**Re: Application SSD-9813
Gosford Alive
136-148 Donnison Street, Gosford (Lot 6 DP598833 and Lot 1 DP540292)
Applicant Lederer Group Pty Ltd**

The following comments are made by the Central Coast Council on the proposed Masterplan and Stage 1 – Demolition.

Drawing Title
ELEVATION SCHEME DONNISON

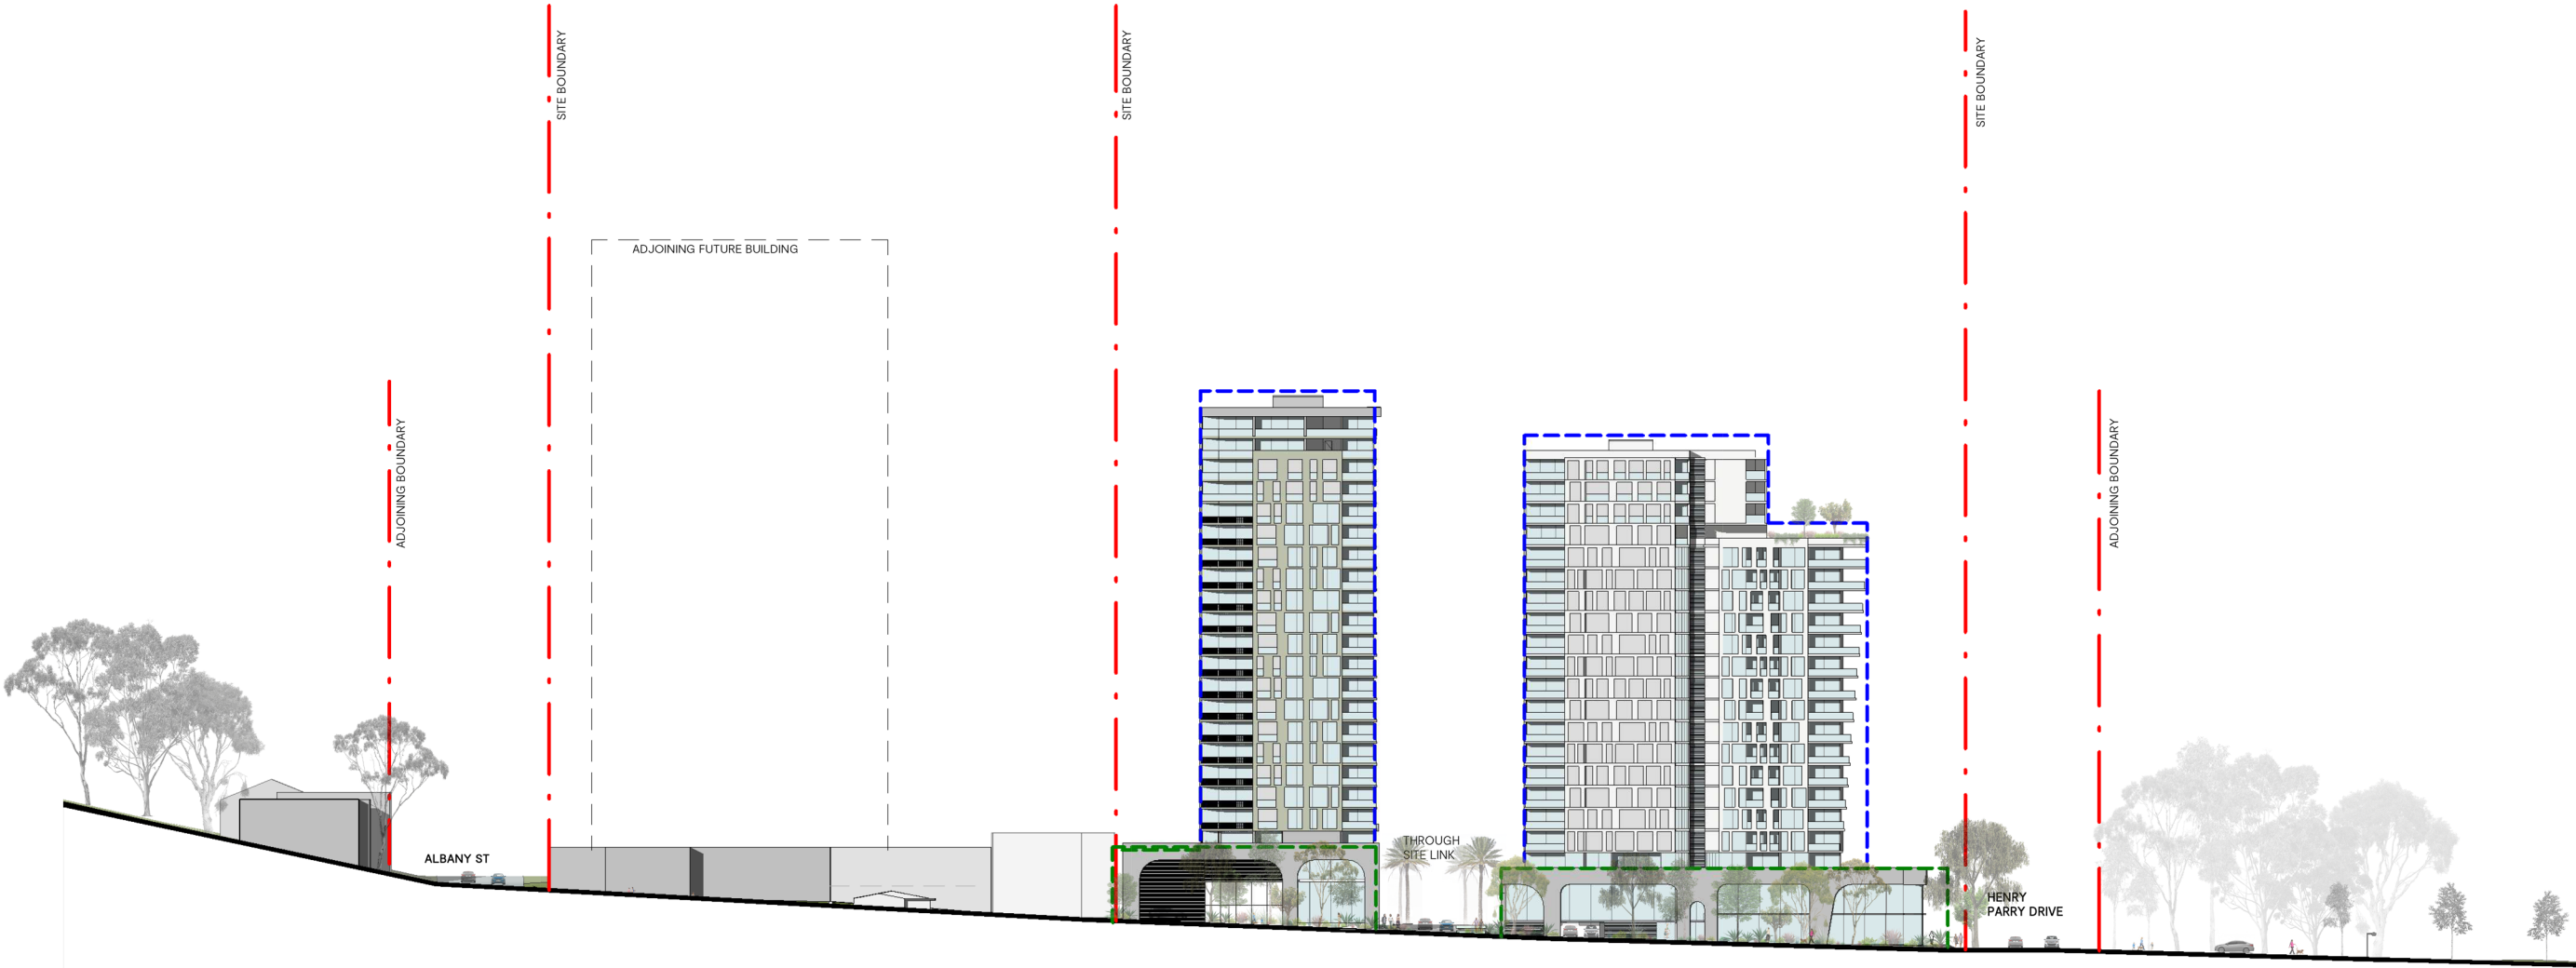
There is particular concern about the scale and visual dominance of tower 1 when viewed from Kibble Park. The "sweep" concept shown in the design report is not apparent due to the similar heights of towers 1 and 3 and the foreground location of tower 1.

The proposal also appears particularly prominent when viewed from the surrounding local streets. Views from both the north and south sections of Henry Parry Drive clearly illustrate the excessive scale and view impacts from these locations.

1. While the Architectural Design Report suggests the proposed concept could be adequate, there is insufficient detailed information provided to properly assess the application. No detailed plans, elevations, sections or material schedule has been provided.
2. The height of tower 1 should be reduced by 5 stories and tower 2 by 3 stories to reduce their overpowering scale and visual impact on Kibble Park to eliminate any overshadowing of Kibble Park and other public space as required by the DCP and to clearly differentiate them from the towers behind.

LANDSCAPE MASTER PLAN

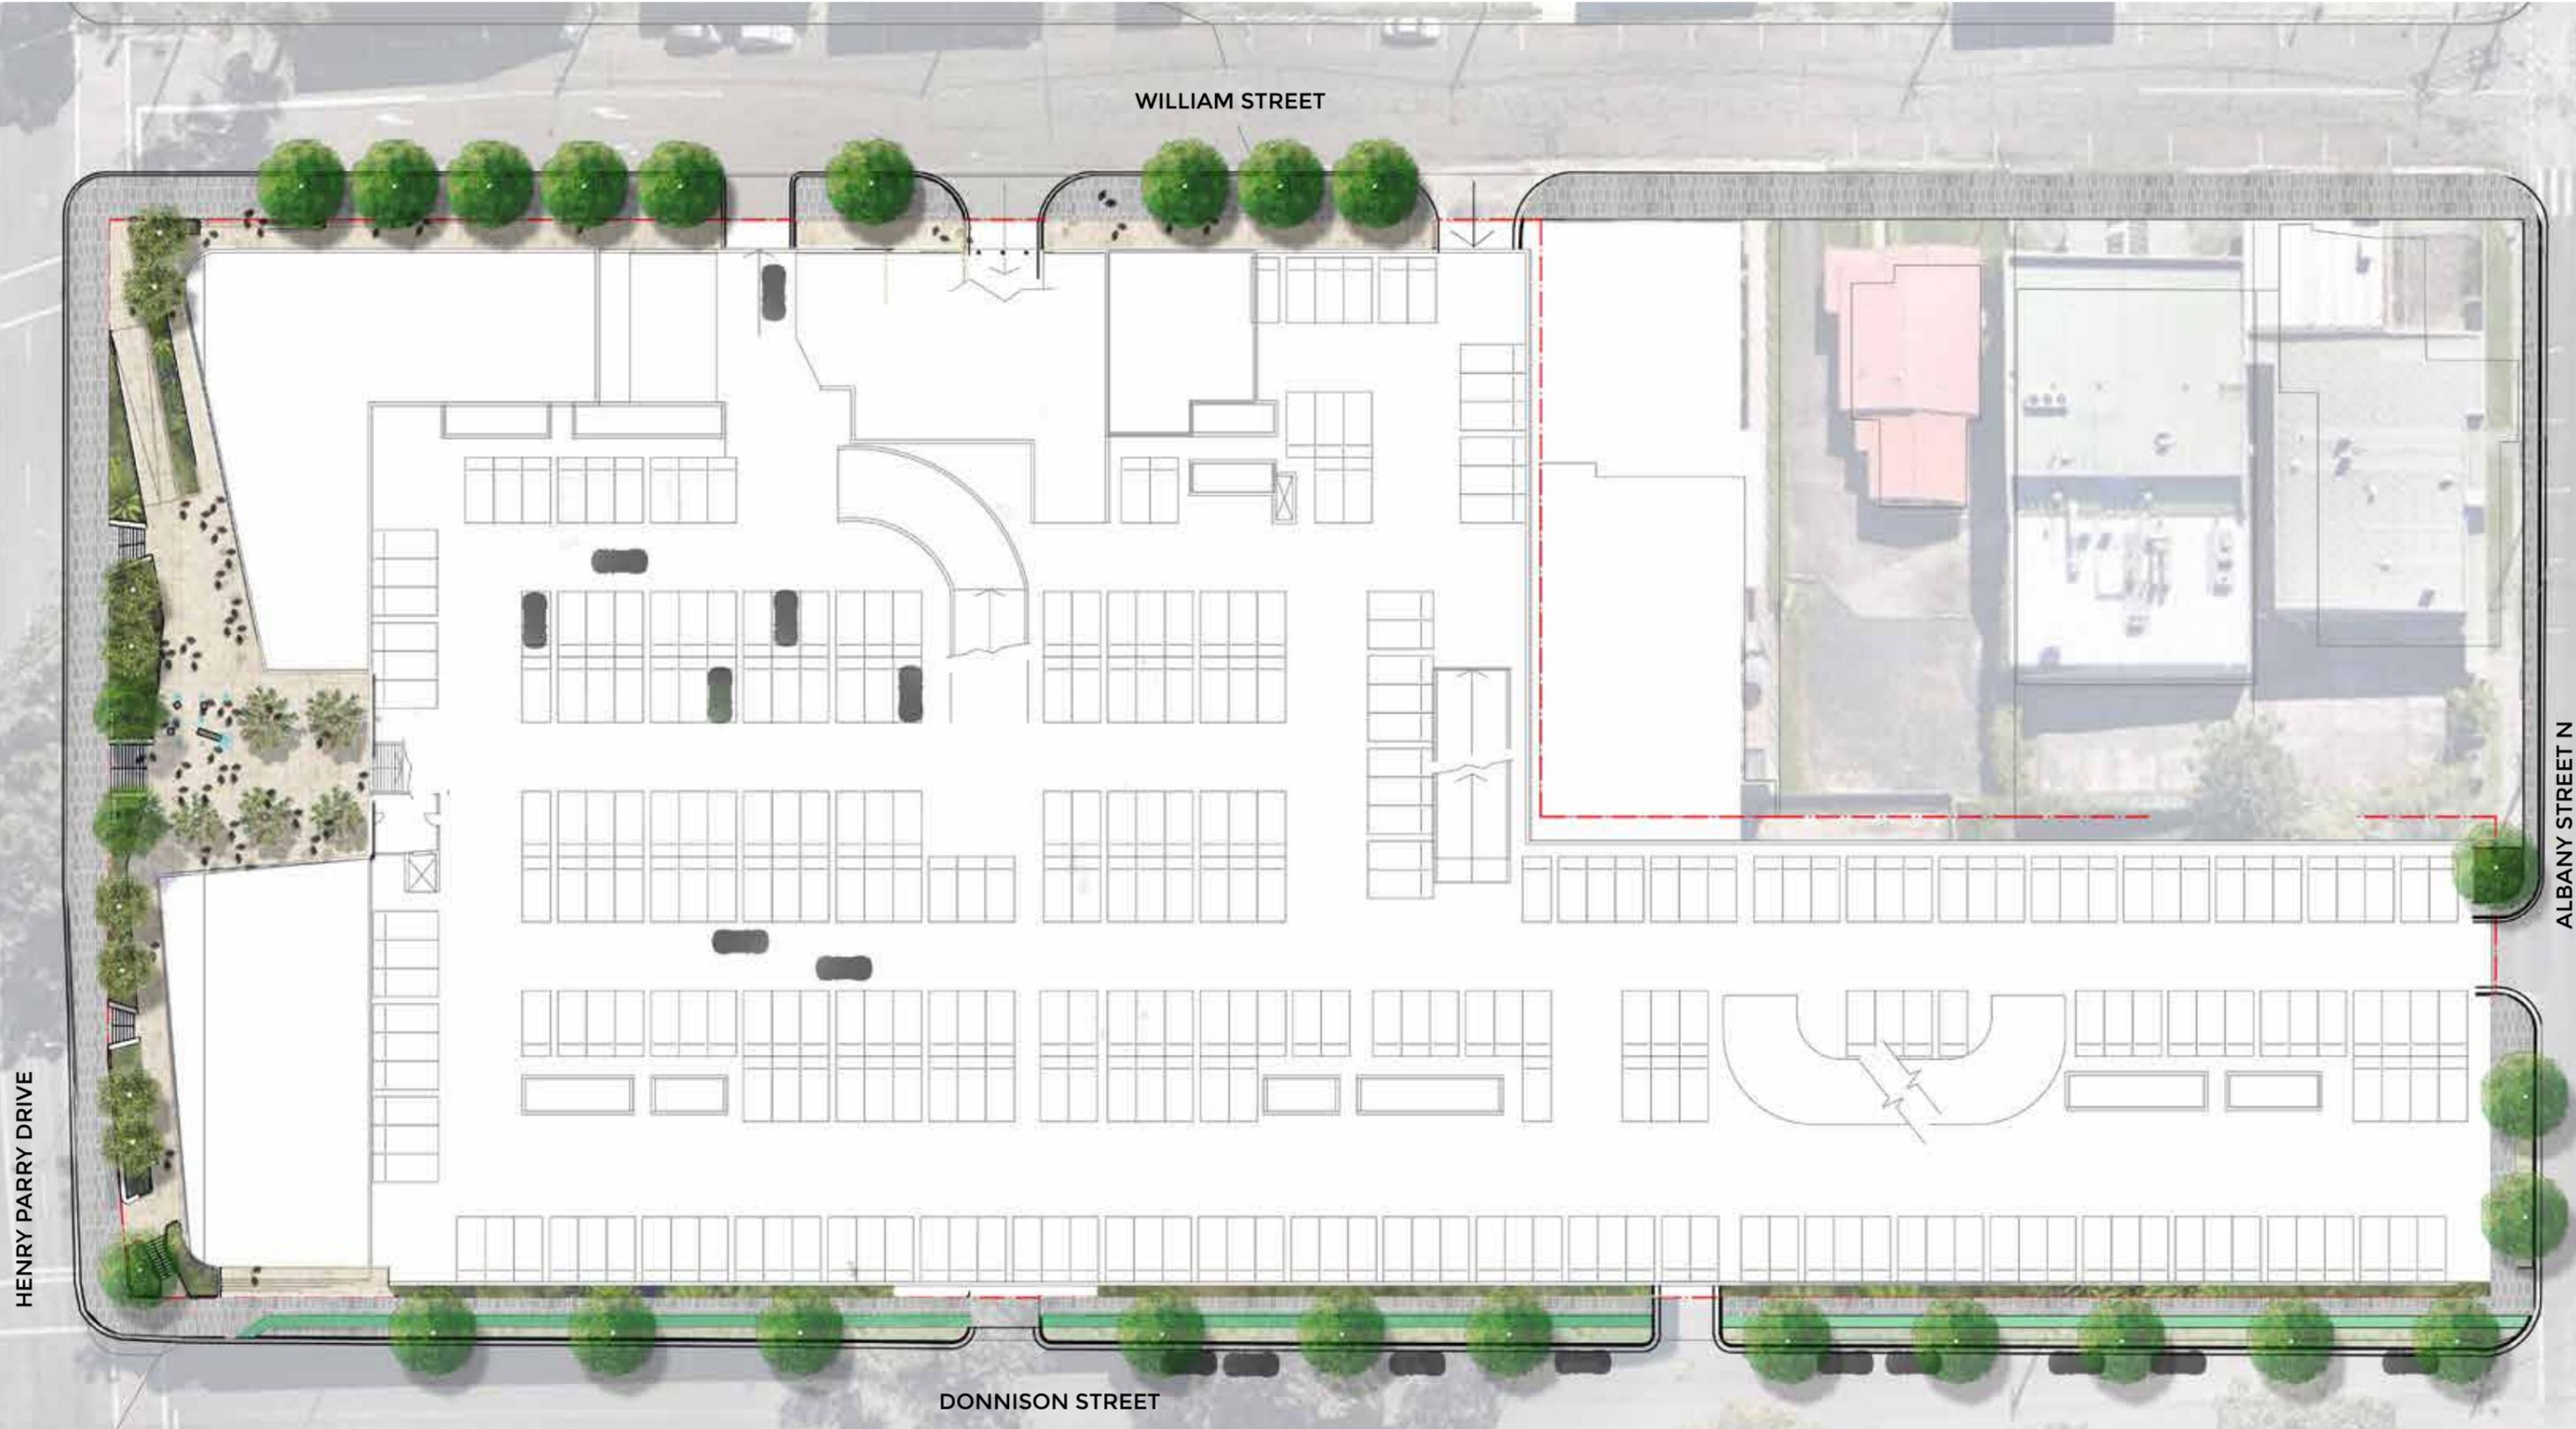
- A landscaped median approximately 1.2m wide is proposed within William Street on the centreline of the road across the frontage of 'Tower 1'.

Comment: This landscaped median is not supported as it would:

- cause a sight obstruction in a heavily trafficked area;
 - would require special infrastructure to irrigate and maintain the plantings in the centreline of the road;
 - alter existing traffic arrangements within this section of road which would impact on access movements related to those properties in this area on the northern side of William Street.
 - landscaping in the centre of this road is contrary to the "Gosford City Centre Streetscape Design Guidelines" prepared by Oculus dated September 2011 for this area of the city centre.
- Narrowing of the road pavement in Henry Parry Drive from the existing 13m-14m width to a total width of 12m (as per the section of Henry Parry Drive on the Landscape Masterplan).

Drawing Title
SHADOW DIAGRAM - 21ST JUNE 1PM
Drawing Number
DA-604

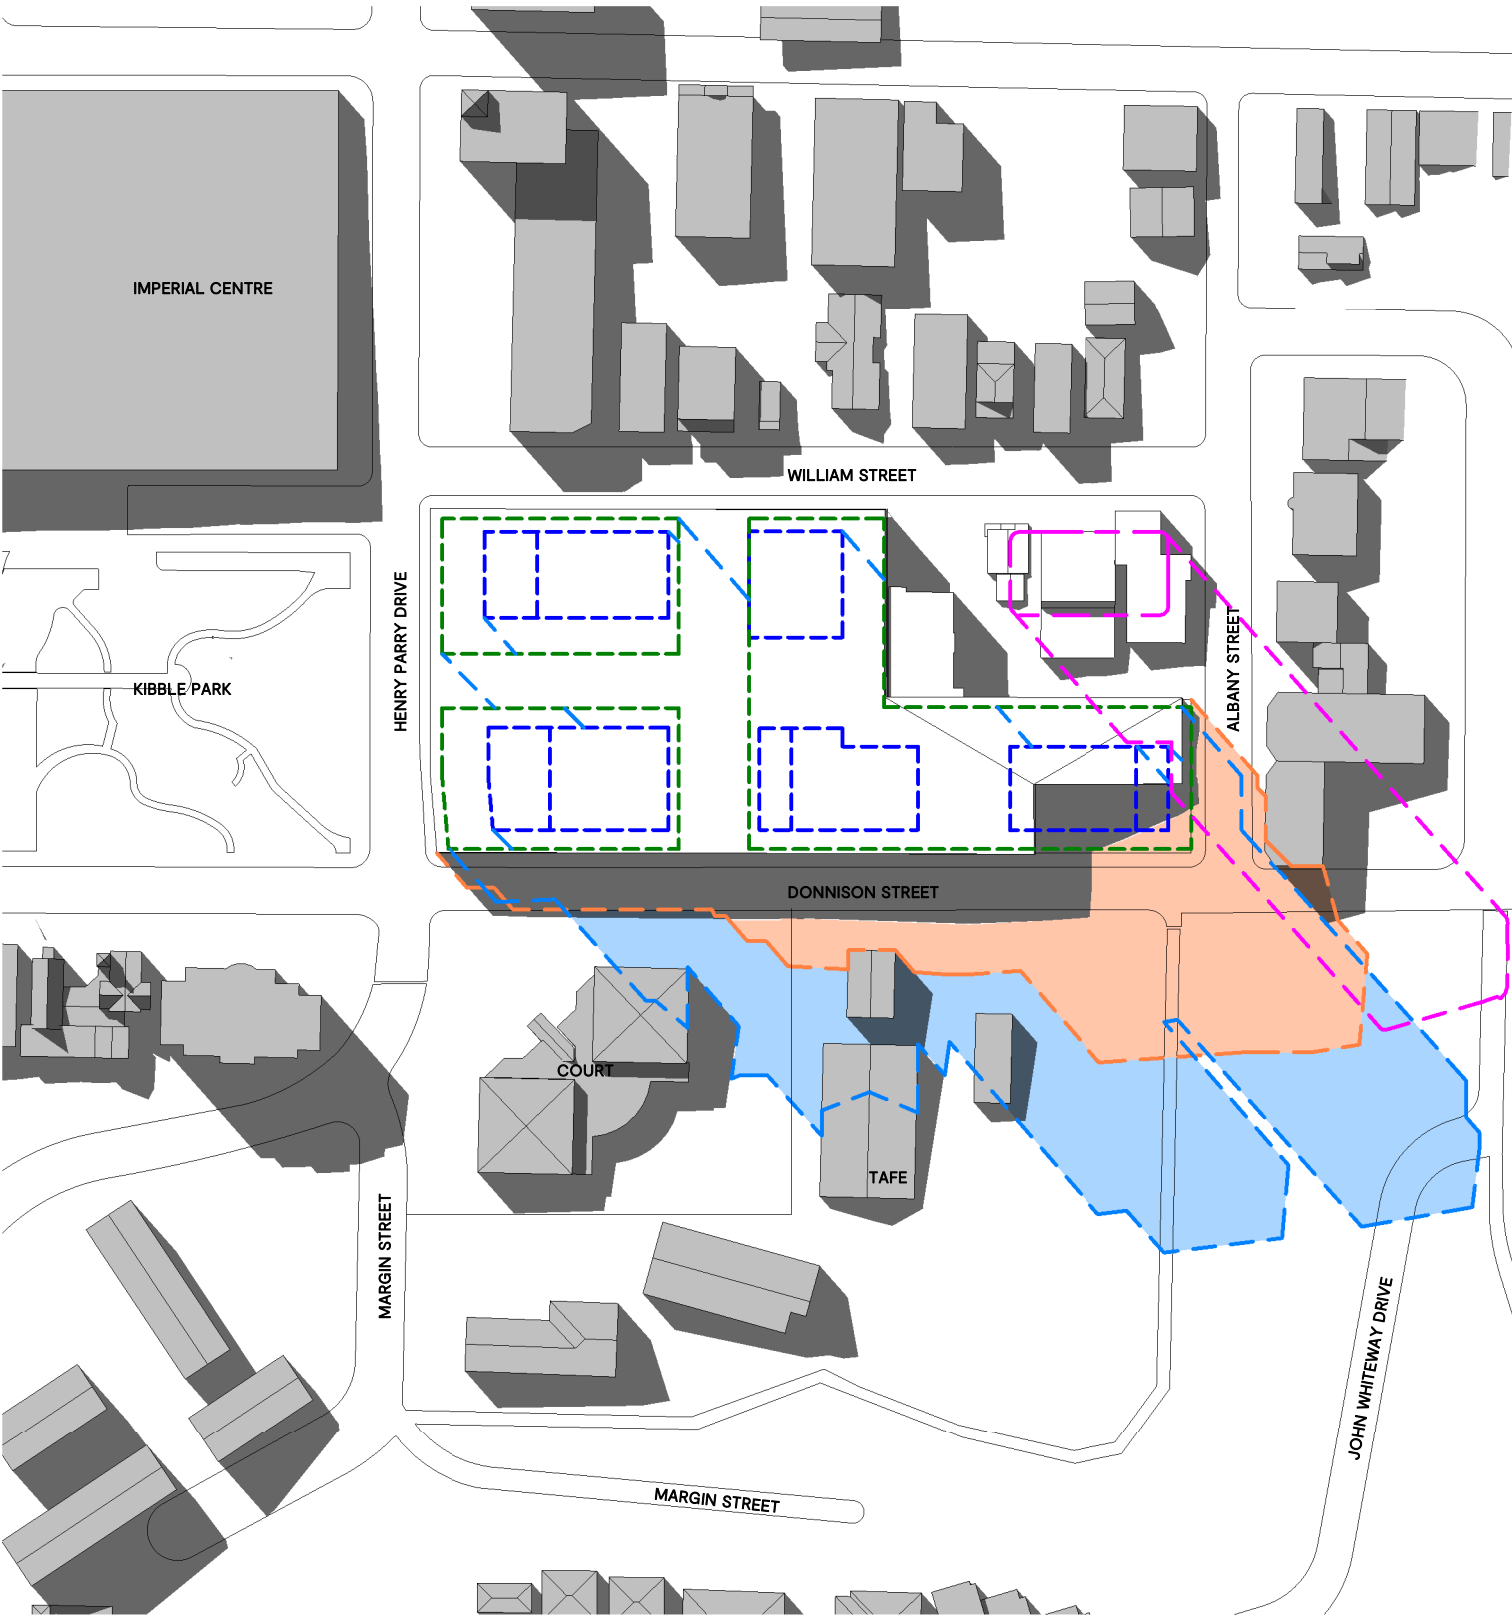
3. Shadow Impacts do not clearly show the shadow impacts particularly in the winter time and therefore cannot be properly assessed.

It is noted that the adjoining future building could be far longer than shown and its shadowing is not included in the shadow diagrams. Even as shown it will result in major overshadowing of communal podium areas for much of the day. This impact must be included in the shadow diagrams to accurately determine possible shadow impacts. It is likely to require amendment of the application to ensure communal open spaces comply with the solar access objectives of the ADG.

3. Provide amended shadow diagrams including those cast by the adjoining future building to accurately determine possible shadow impacts. Including shadows from the suggested building clearly shows the majority of the communal open space on podiums will be overshadowed for most of the day. Shadow diagrams for all times and months should be provided. It is noted that for much of summer the pool is overshadowed between 11 and 1. It may be necessary to modify the design of towers 1 and 3 to address this issue.
4. The entire length of Donnison Street should include some form of active street front. Carparking on the street front is not supported. This should either be wrapped by residential or commercial use as required by the DCP2018.
